88 Preble- revisions re

Evan and Silas

DRAWN BY  
SHEET TITLE **Site Layout and Utility Plan**

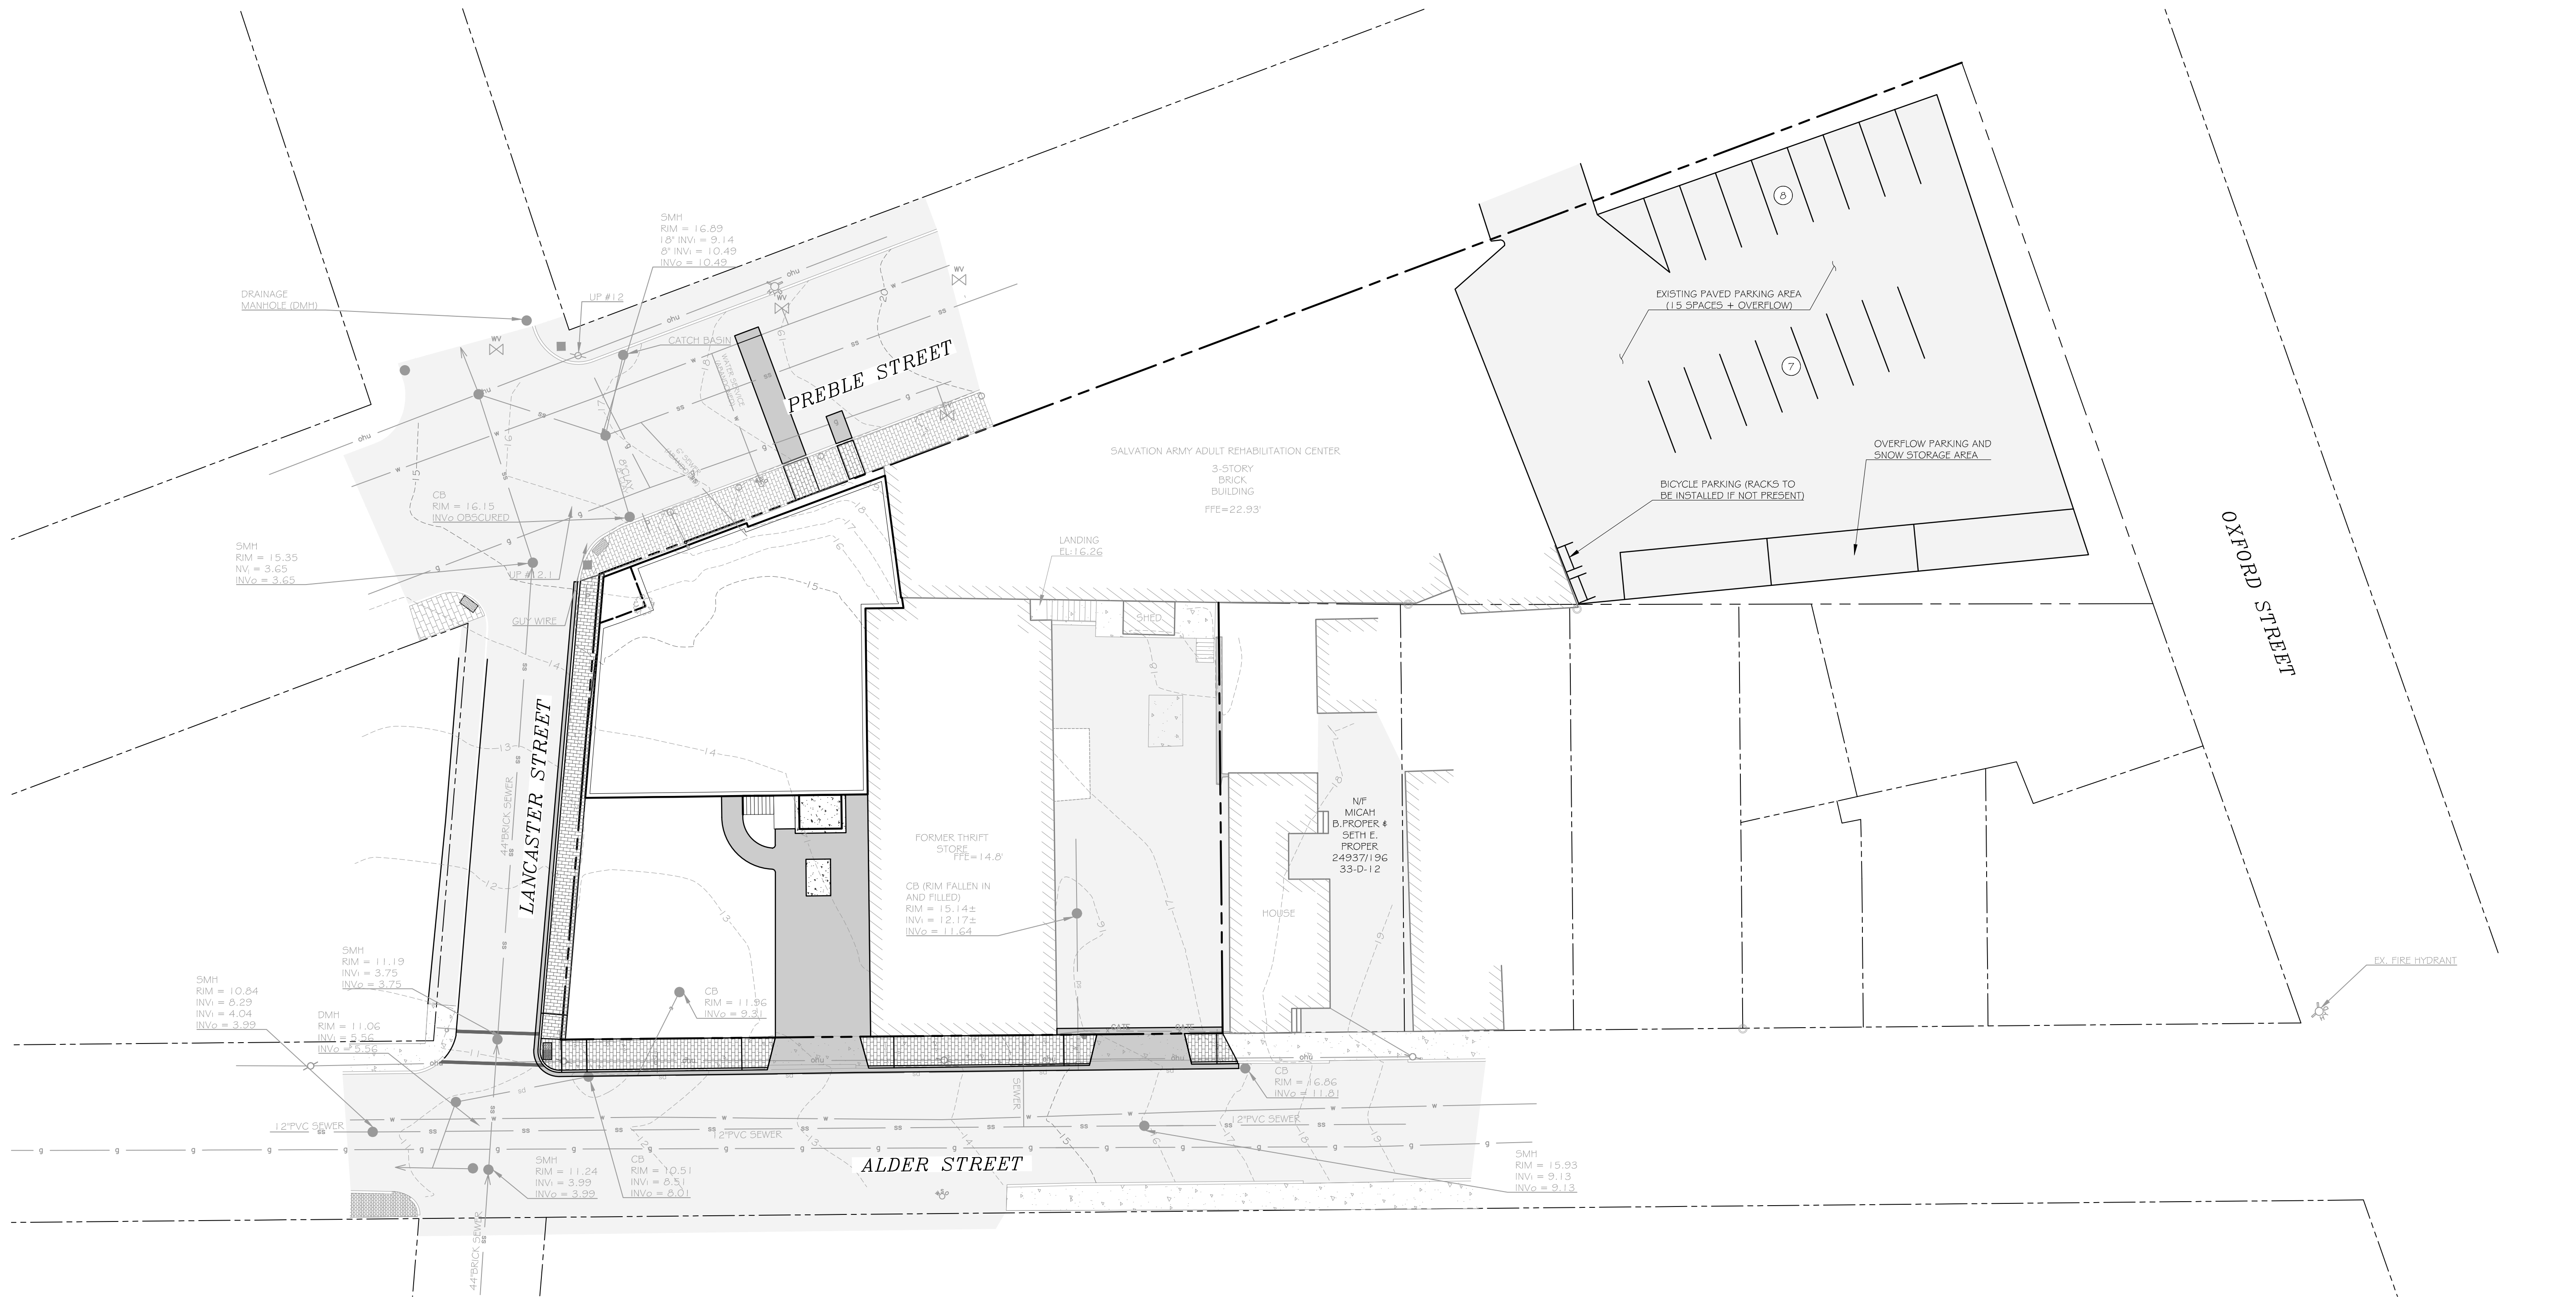
C100, C200, and C300: Show crossbars in crosswalk as per Tech Std (2 ft white, then 2 ft black) across top and bottom of Lancaster (see Tech Std extract below) and show tipdown as diagonal at corner of Lancaster/Alder to match detail in C402

2 BITUMINOUS DRIVEWAY APRON DETAIL
C401 NOT TO SCALE

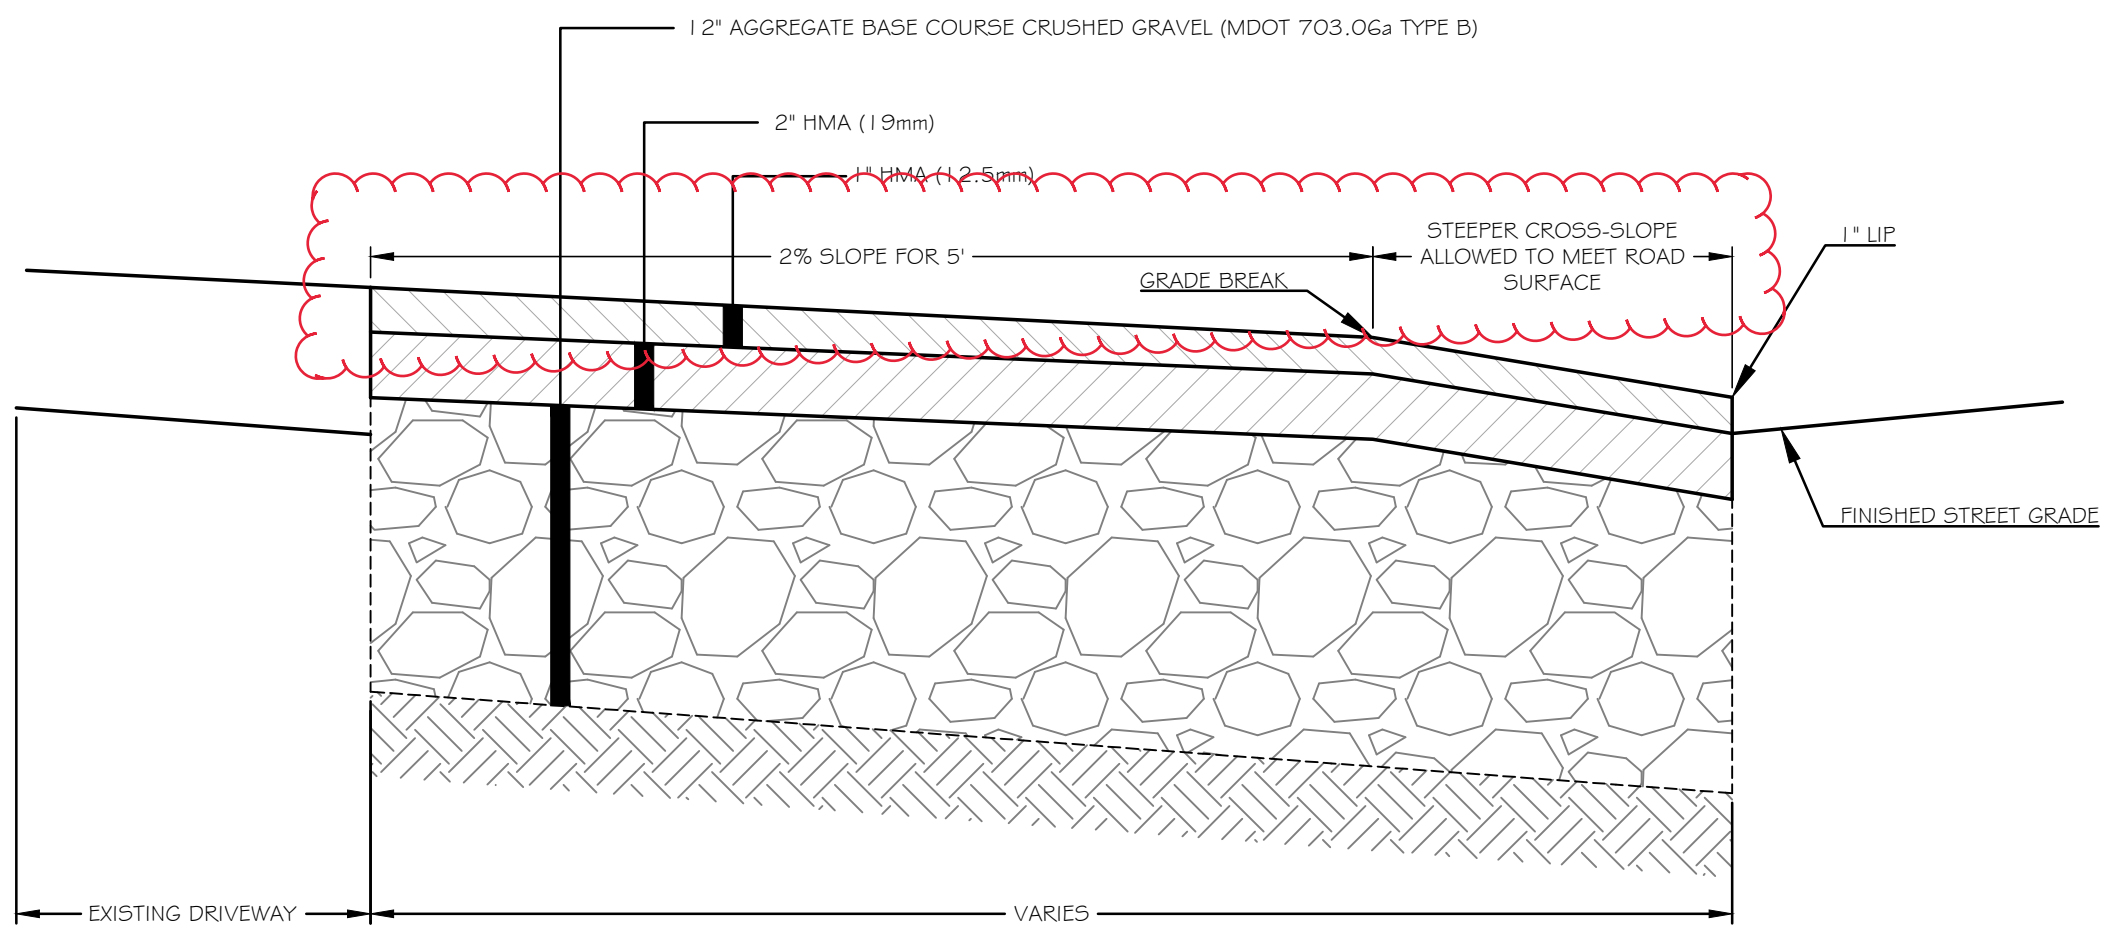
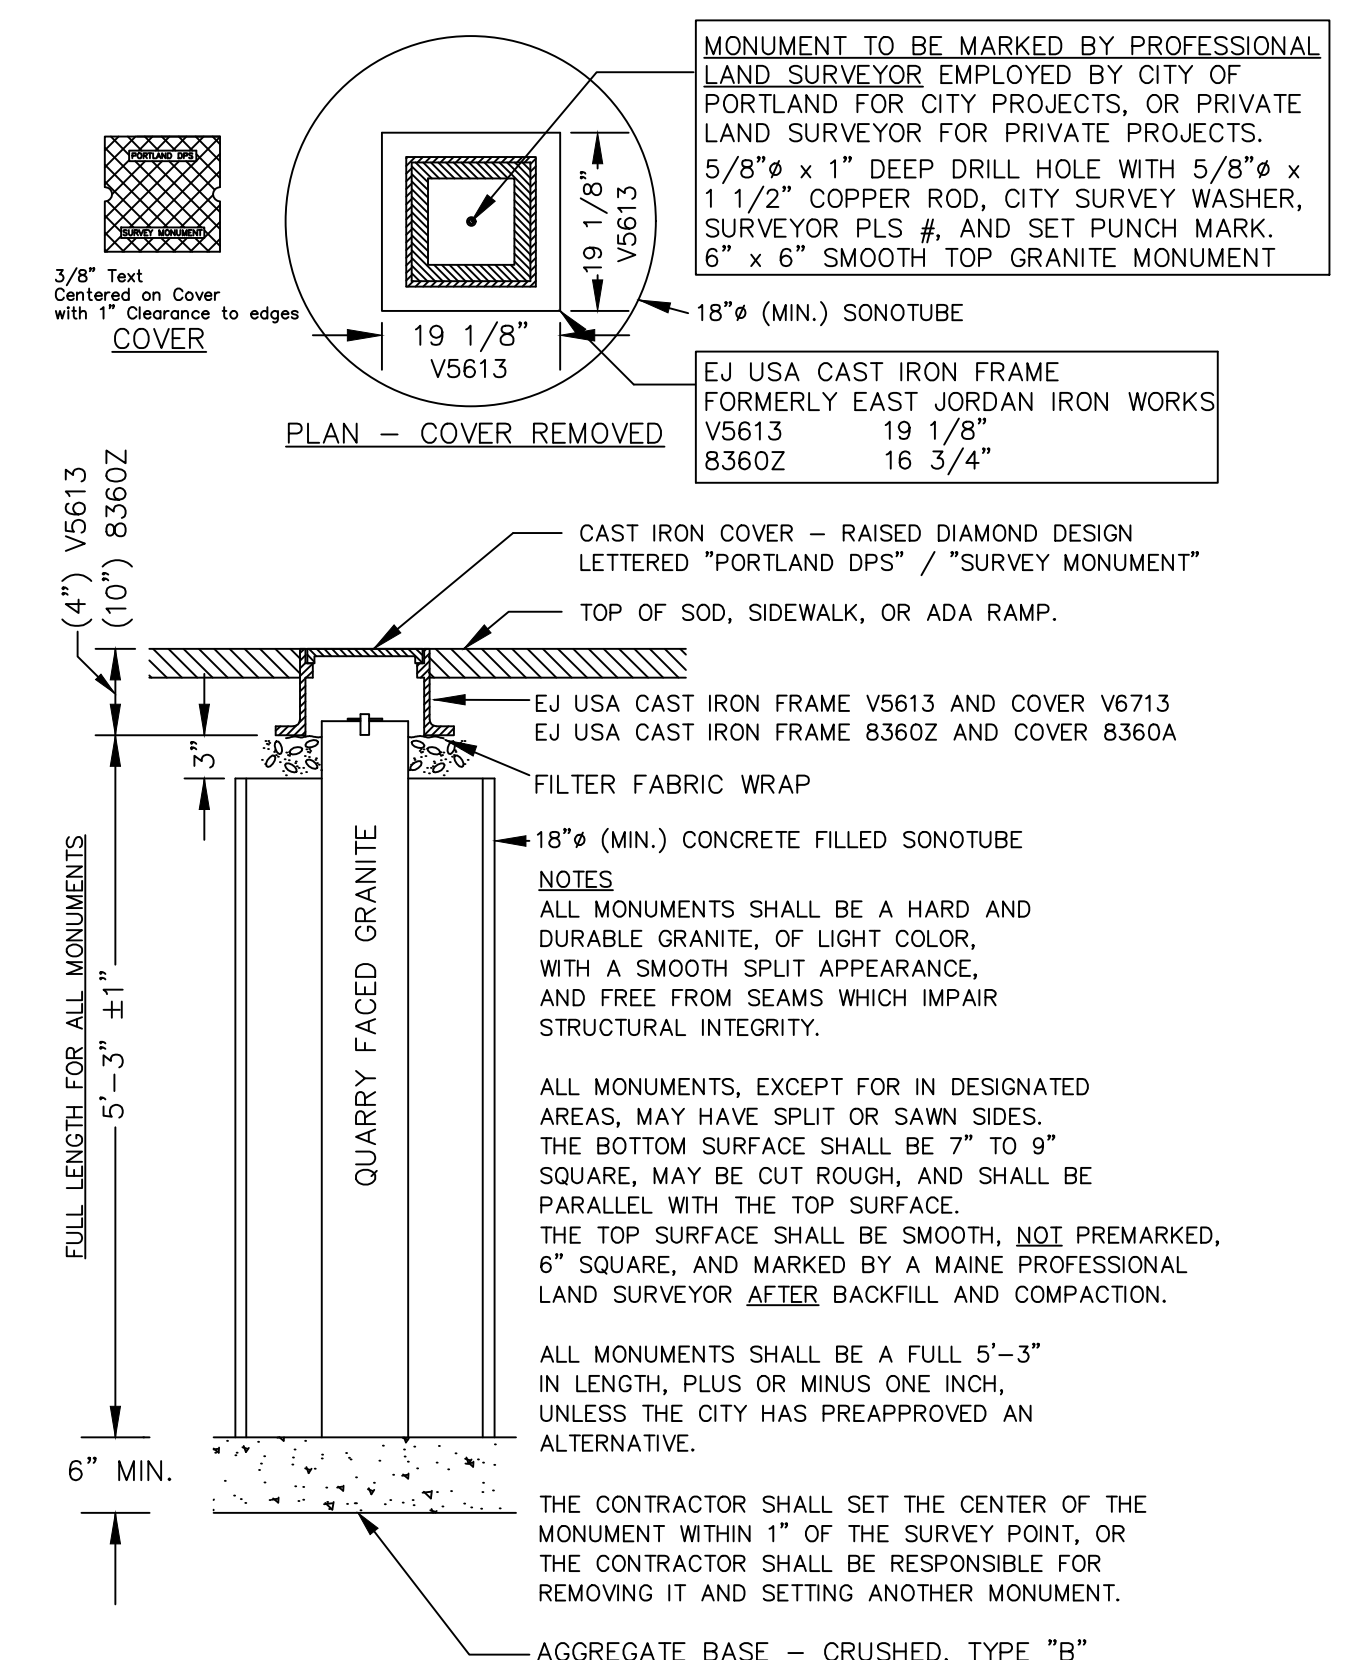
C401 (detail 2): Add note that 2% maximum slope for the pedestrian access route (ie so meets ADA)

11 CURB RAMP DETAIL AT CROSSWALK
C402 NOT TO SCALE

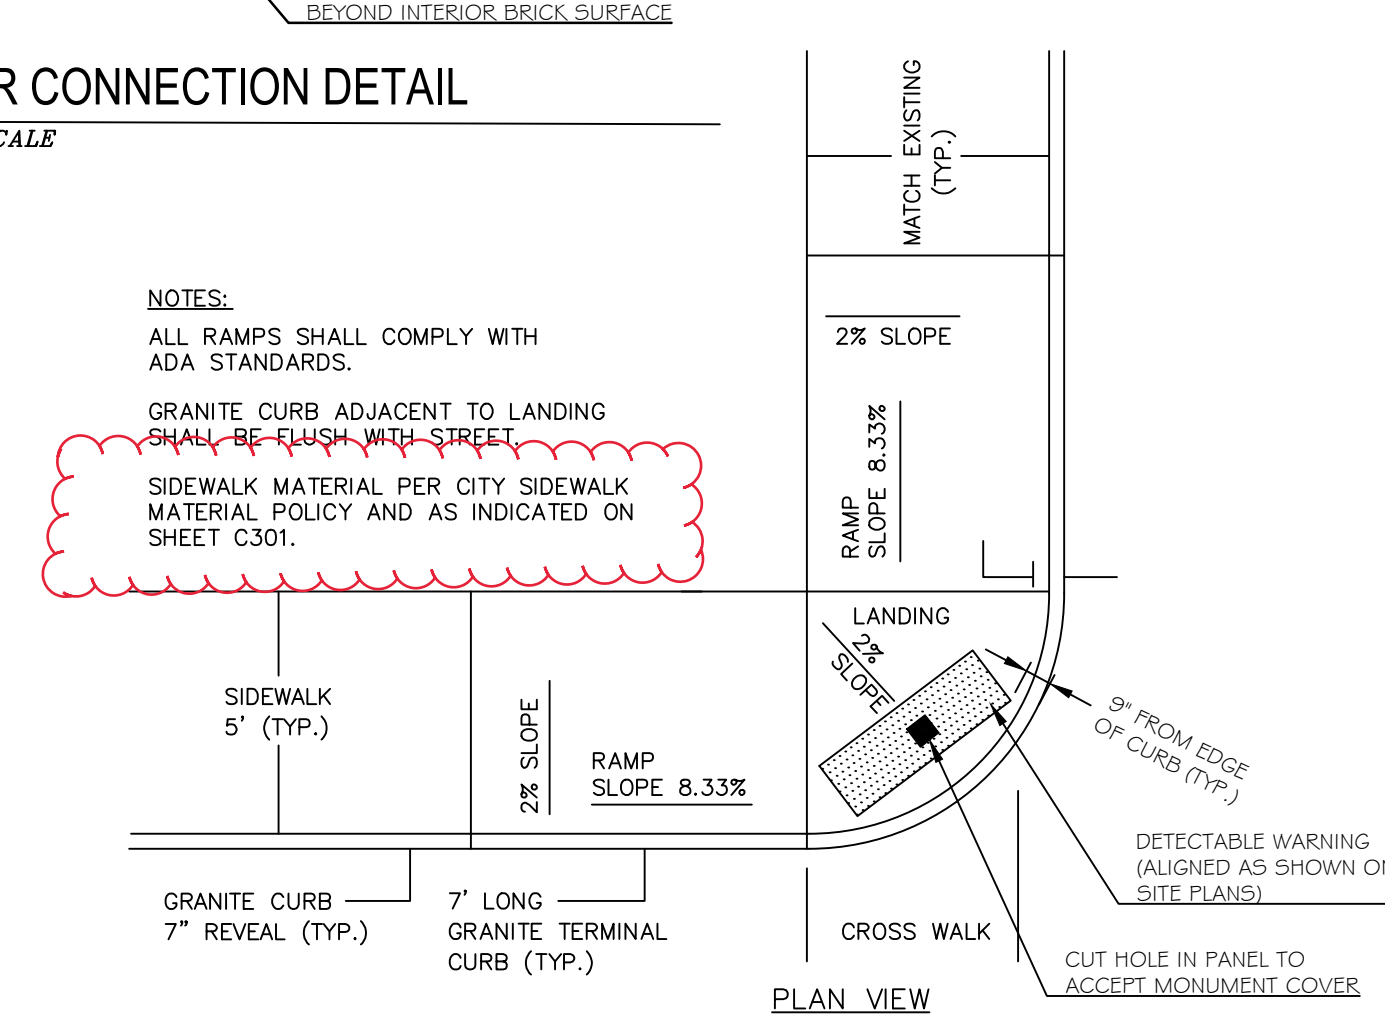
C402 (detail 11): Show the materials of the sidewalks as that has been decided (orientation of ramp is correct)
